Our Reference: SYD20/01146/04
Departments Reference: SSD-9794683

EXHIBITION OF EIS - OAKDALE WEST ESTATE STAGE 3 - WAREHOUSES 2A, 2C, 2D, 2E - 2 - 18 ALDINGTON ROAD, KEMPS CREEK

RESPONSE TO SUBMISSIONS - OAKDALE WEST ESTATE STAGE 3 - WAREHOUSES 2A, 2C, 2D, 2E - 2 - 18 ALDINGTON ROAD, KEMPS CREEK

ESTATE ROAD 03

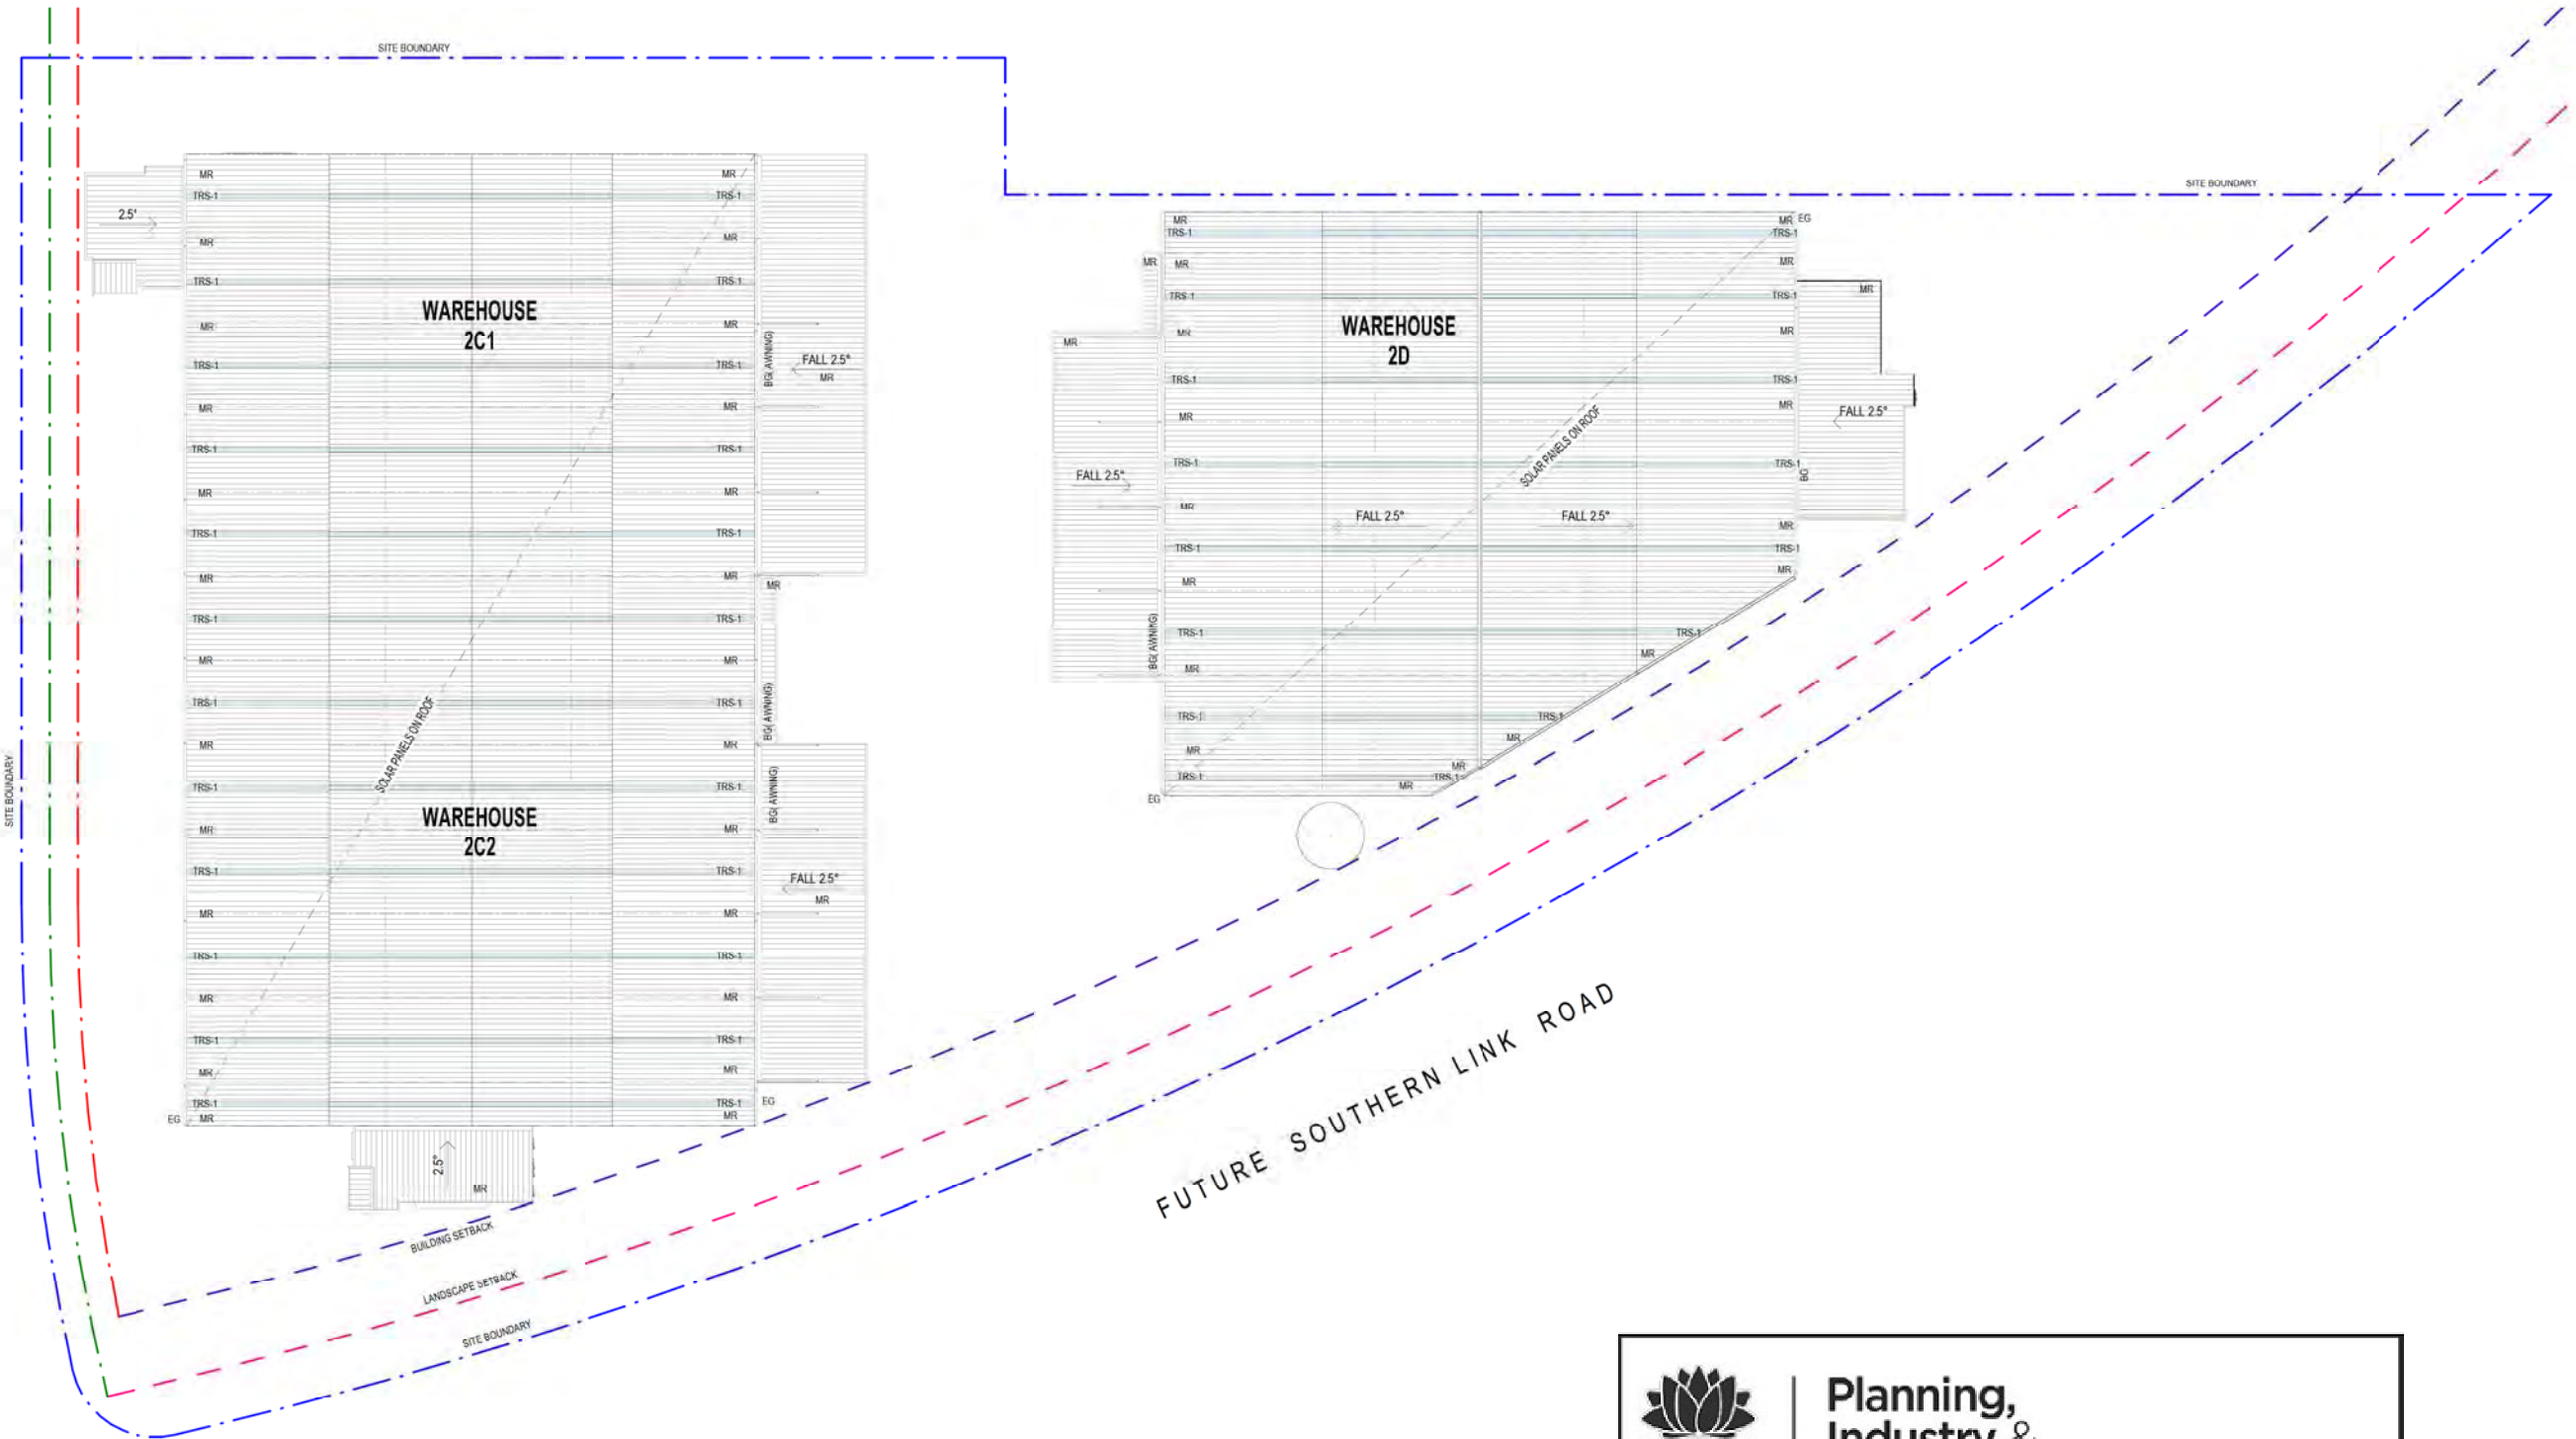
In the Response to Submissions, the proponent has provided some justification regarding the access to building 2C remaining at the proposed location. Whilst TfNSW understands that the modelling indicates a queue length of 63 metres, the location of the access is not supported. Direct access to the collector roads should be kept to a minimum and away from major intersections to support traffic efficiency and to reduce conflict points along collector roads.

The swept path plans for building 2C indicate that simultaneous entry/exit cannot be achieved with the largest vehicle from Estate Road 01. The location of this access point is close to the intersection of the SLR and could lead to queuing on the collector road where 2 opposing vehicles are attempting to use the access at the same time. This could affect through movements and cause congestion at the intersection with SLR.

It is recommended that the access for vehicular parking for building 2C be relocated north as far from the intersection with the Southern Link Road (SLR) as possible to reduce fragmented road side activity near key decision points.

It is recommended that the design of the access point allows for simultaneous entry/exit movements of the largest vehicle. The swept path of the longest vehicle entering and exiting the subject site, shall be in accordance with AUSTROADS.
